From: Natalie McKellar [REDACTED]
Sent: 11 July 2022 14:16
To: Jessica Riches <Jessica.Riches@arun.gov.uk>
Cc: Office [REDACTED]
Subject: FW: Ryefields: AL/31/22/PL

From: Jessica Riches <jessica.riches@arun.gov.uk>
Sent: 07 July 2022 16:41
To: Kerry Simmon [REDACTED]
Cc: Edward Rees [REDACTED]
Subject: Ryefields: AL/31/22/PL

VISIBILITY SPLAYS AT ACCESS
2M X 23M AND 2M X 15M

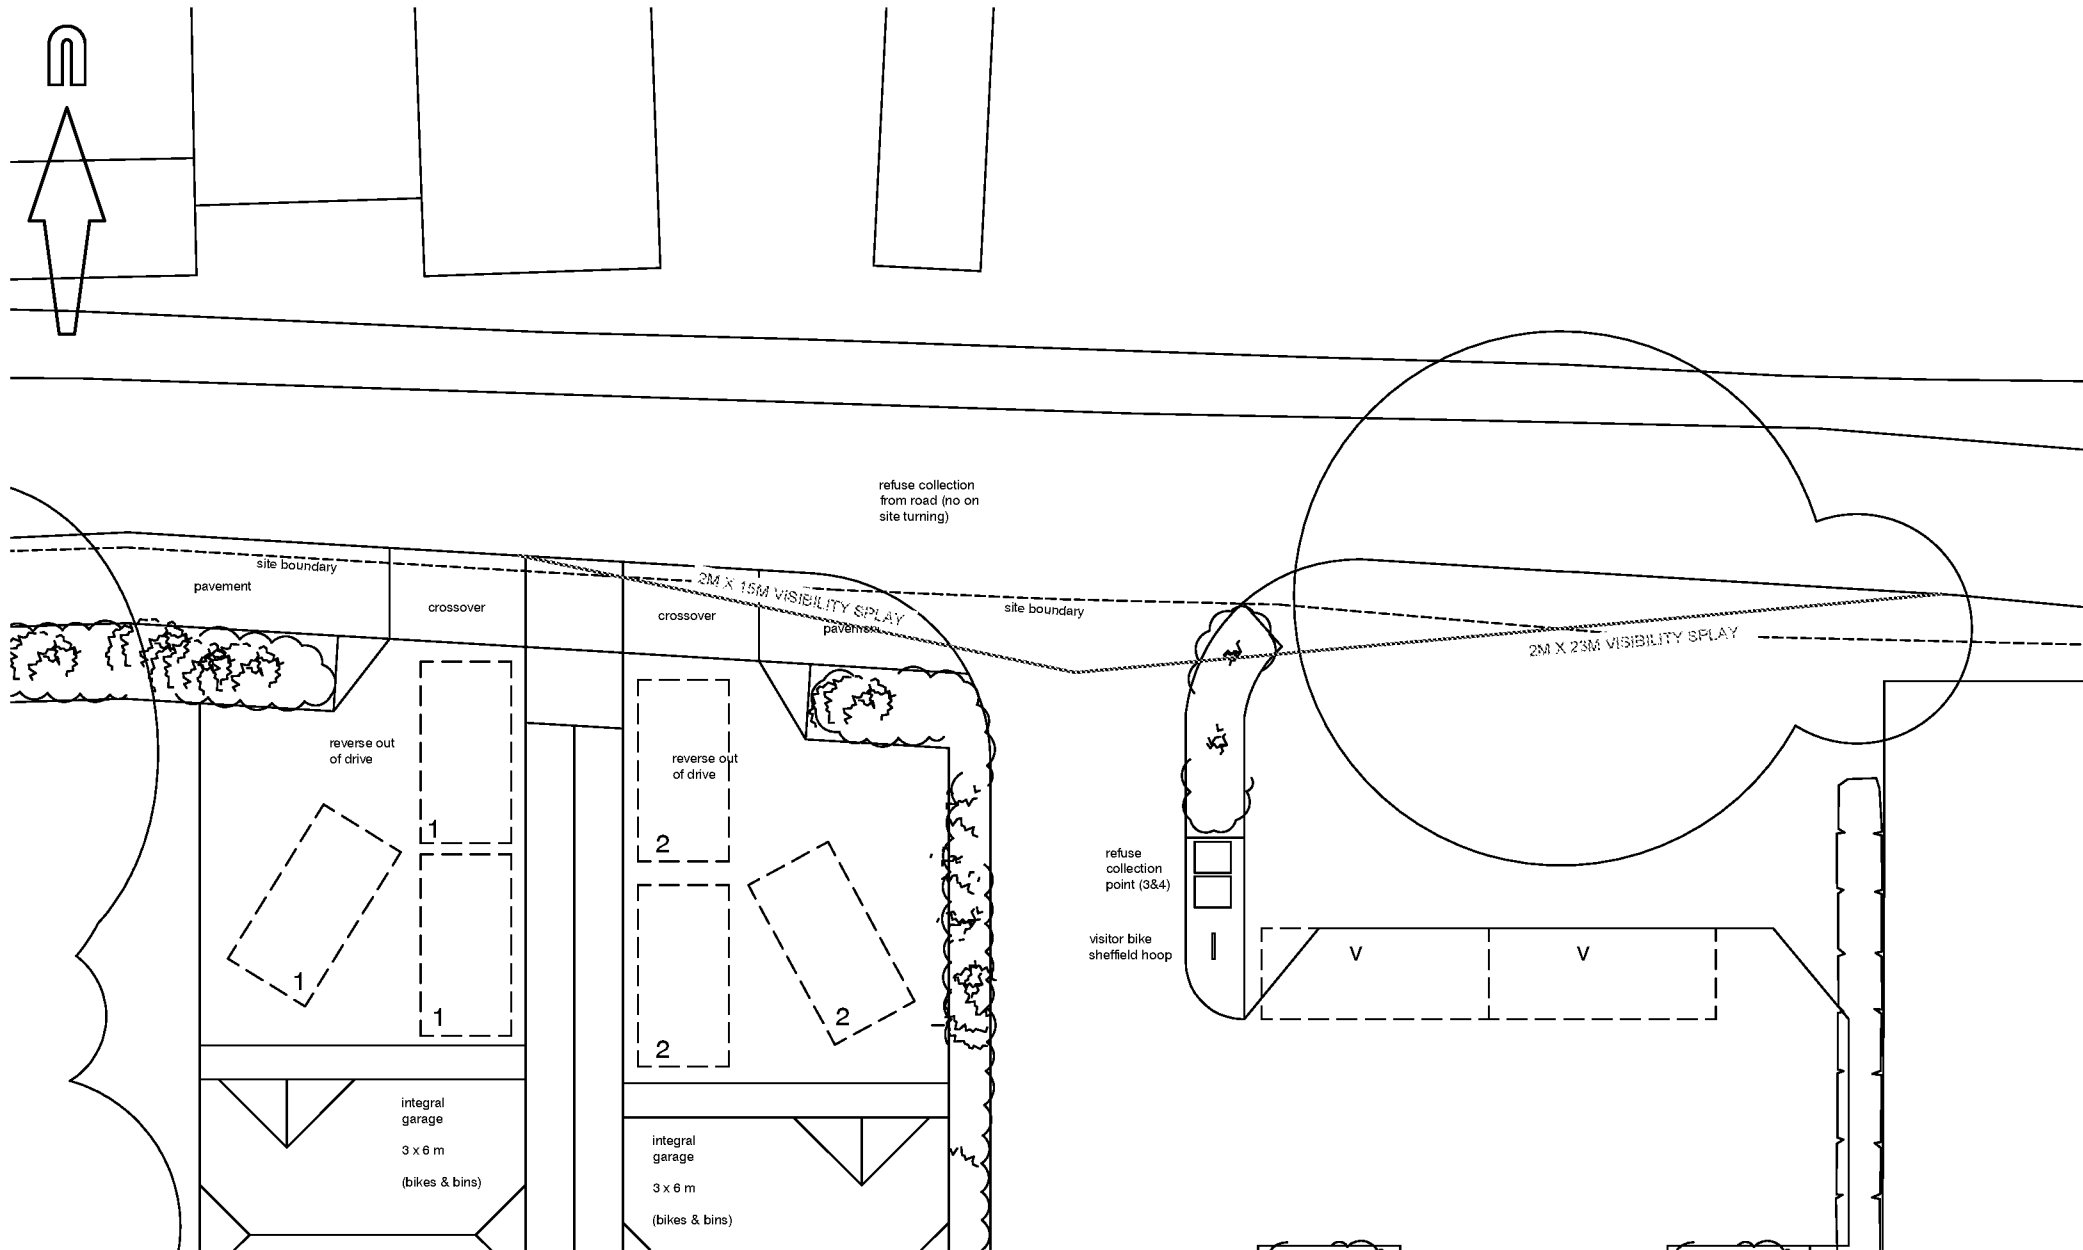
I think the proposed layout still presents some issues, especially with the access points and visibility splays showing that the T15 tree may interfere and be at risk of clearance. Therefore, it is recommended that you explore the site with two pairs of semi-detached houses, with access for plots 3 & 4 shifting to the west of the site to ensure the retention of T15. As a result, plot 1 would become slightly smaller as a 3-bedroom dwelling, and plot 2 moves further to the west to accommodate the shifted access.

In terms of the plans submitted, we would be expecting fully revised plans, which would include revising any arboricultural statements and retention plans based on any new layouts. Additionally, we would need a plan which more accurately details that the access works will not impinge on the retention of the protected tree (T15).

Figure 4: Proposed site plan

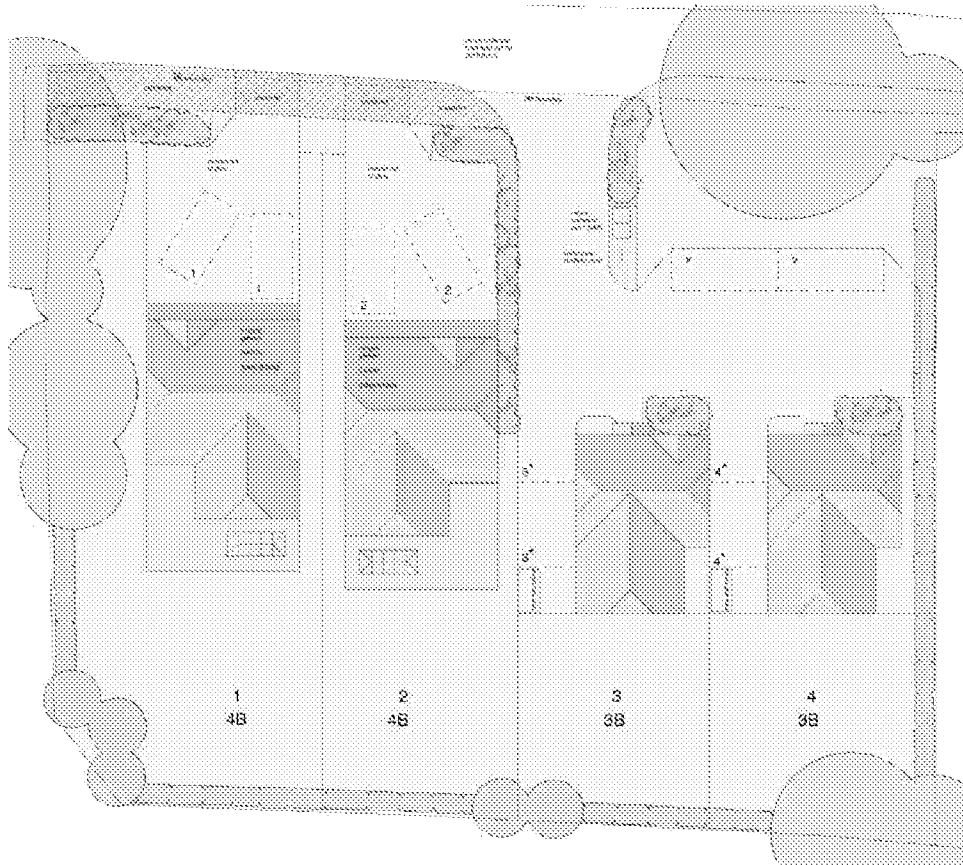
Plot 1 & Plot 2, which has been turned into a three bedroom requires 2 on plot car parking spaces each. I think with two pairs of semi-detached houses, you may wish to look at how to better incorporate parking within the scheme, and ultimately remove the integral garage from the 3 beds to provide a better ground floor living environment. Plot 2 parking could become tandem and located to the side of the dwelling to allow the shared driveway for plots 3 & 4.

Legend

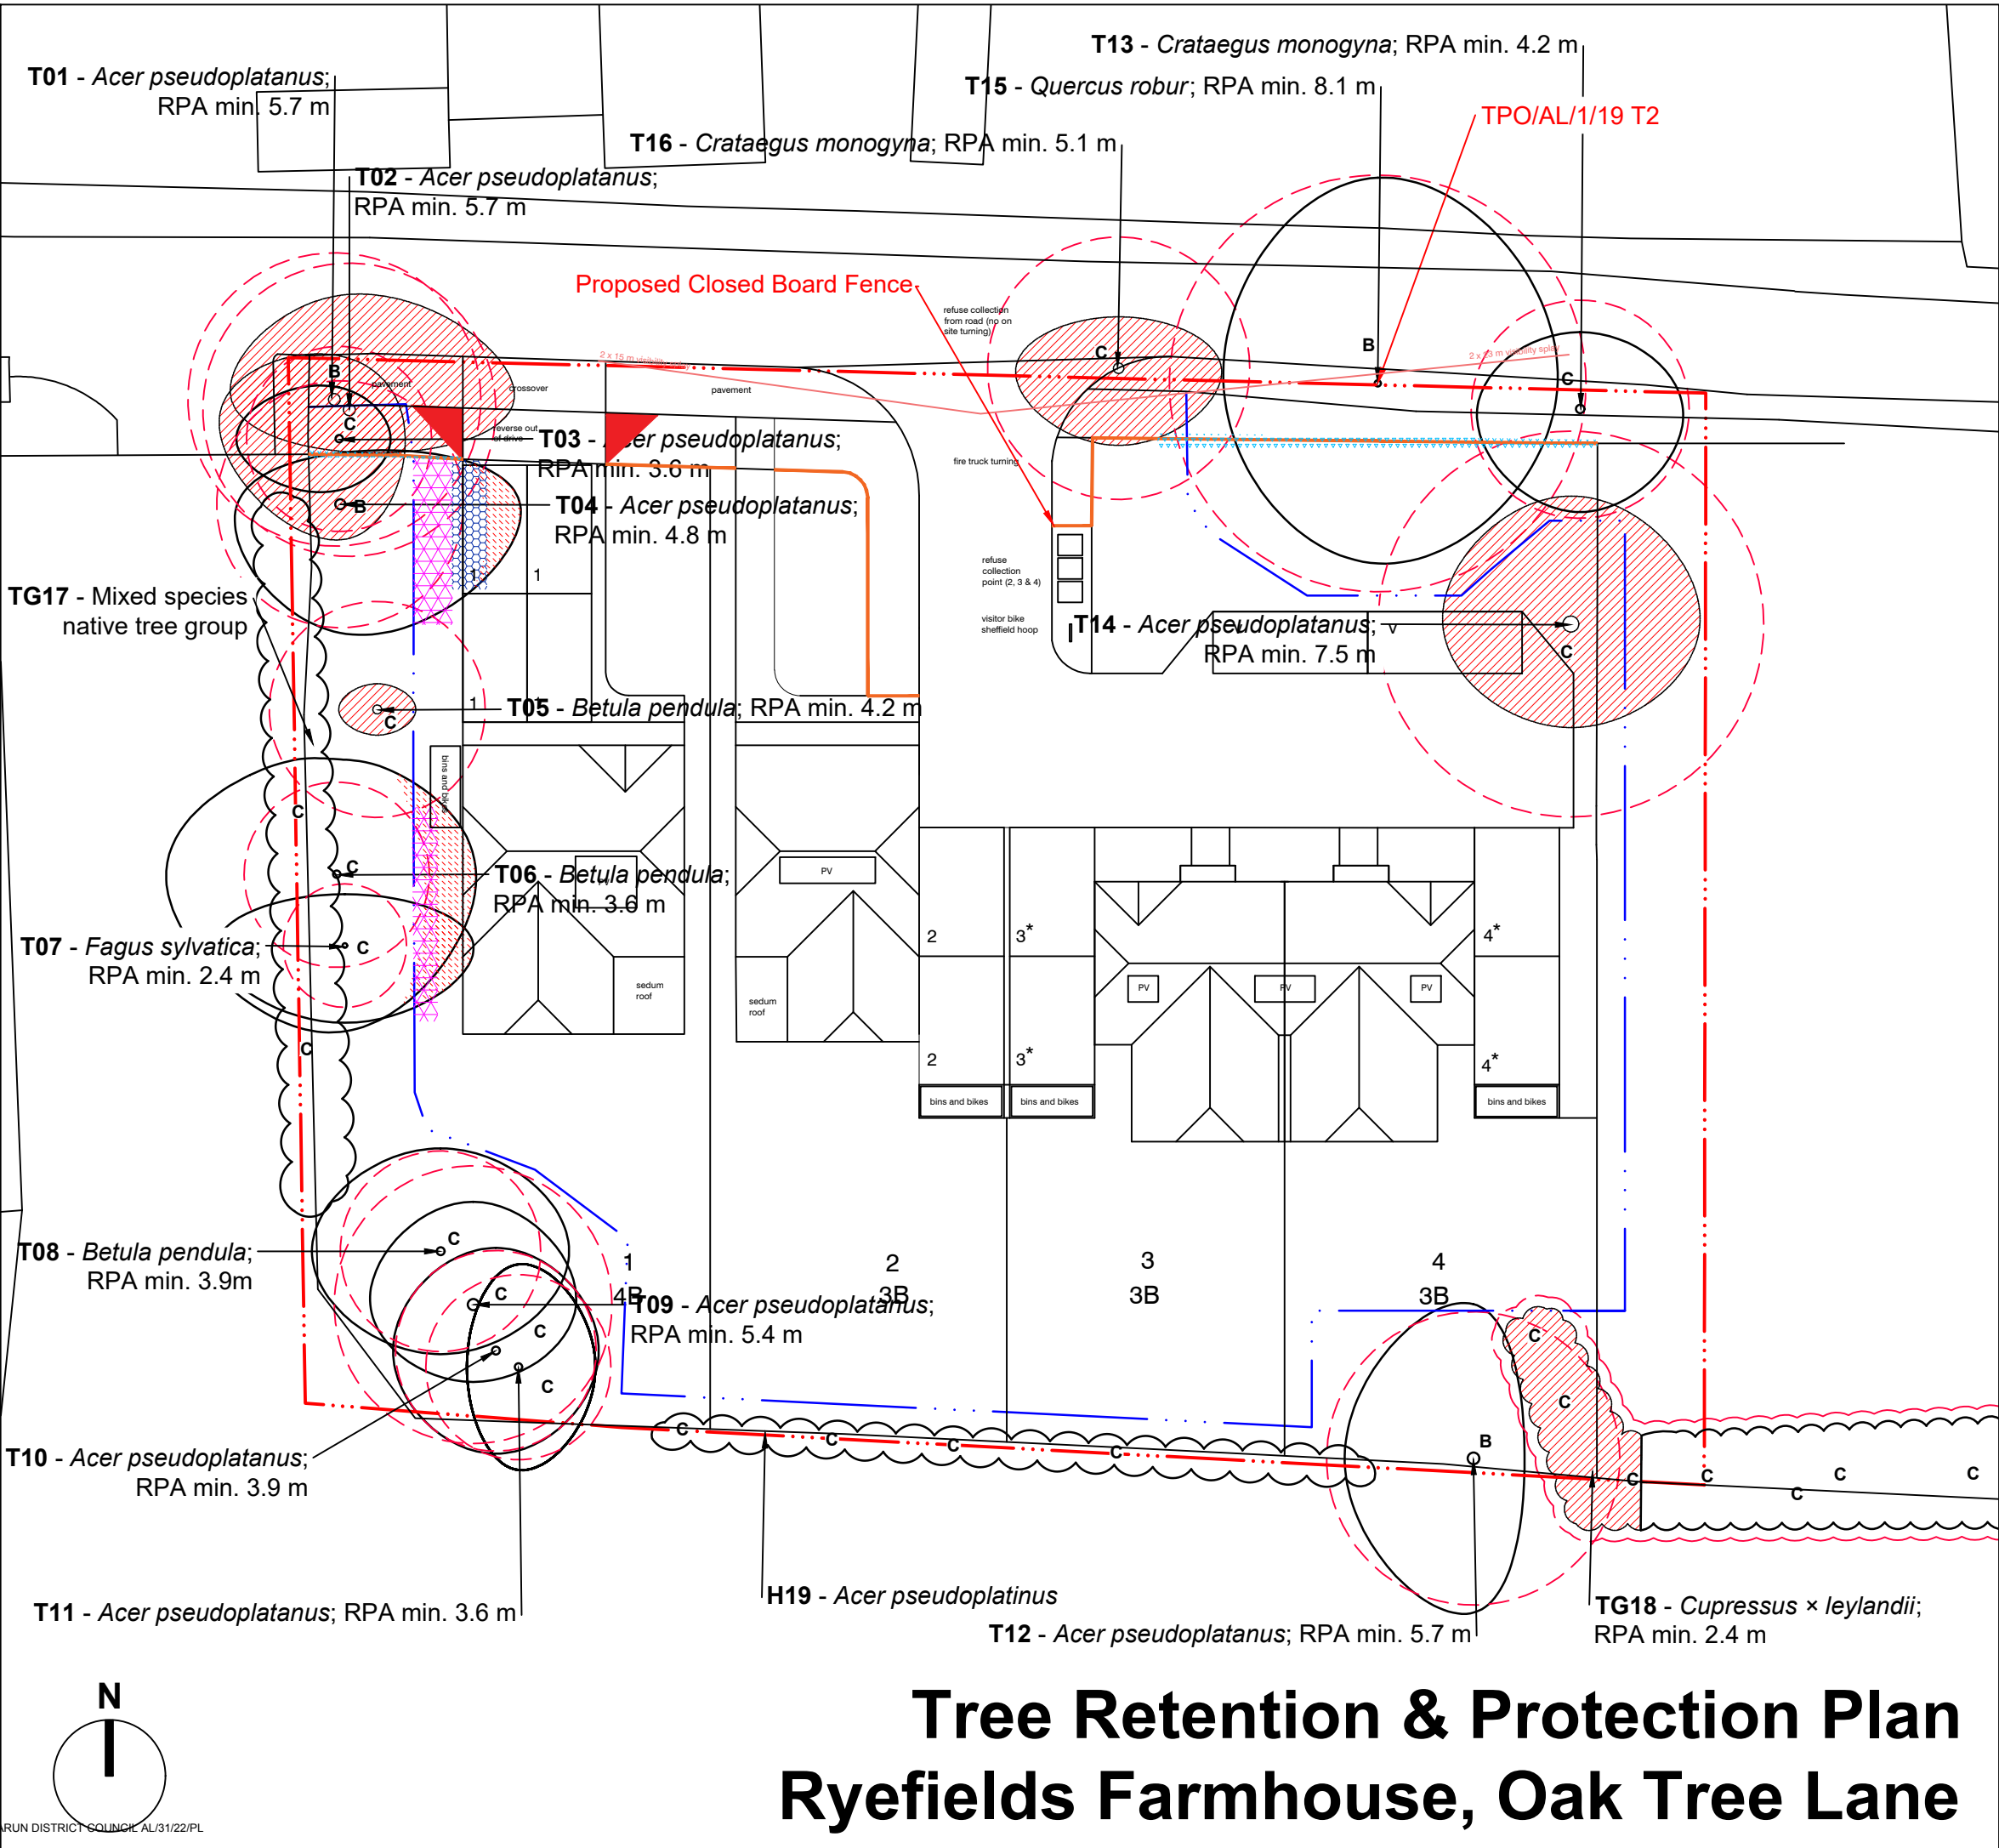
In terms of BNG, I appreciate the provision of some additional trees and other vegetation incorporated into the development, however only 4 new trees are proposed whilst 5 are proposed to be removed. I think this could be improved, particularly to the east boundary of the plots.
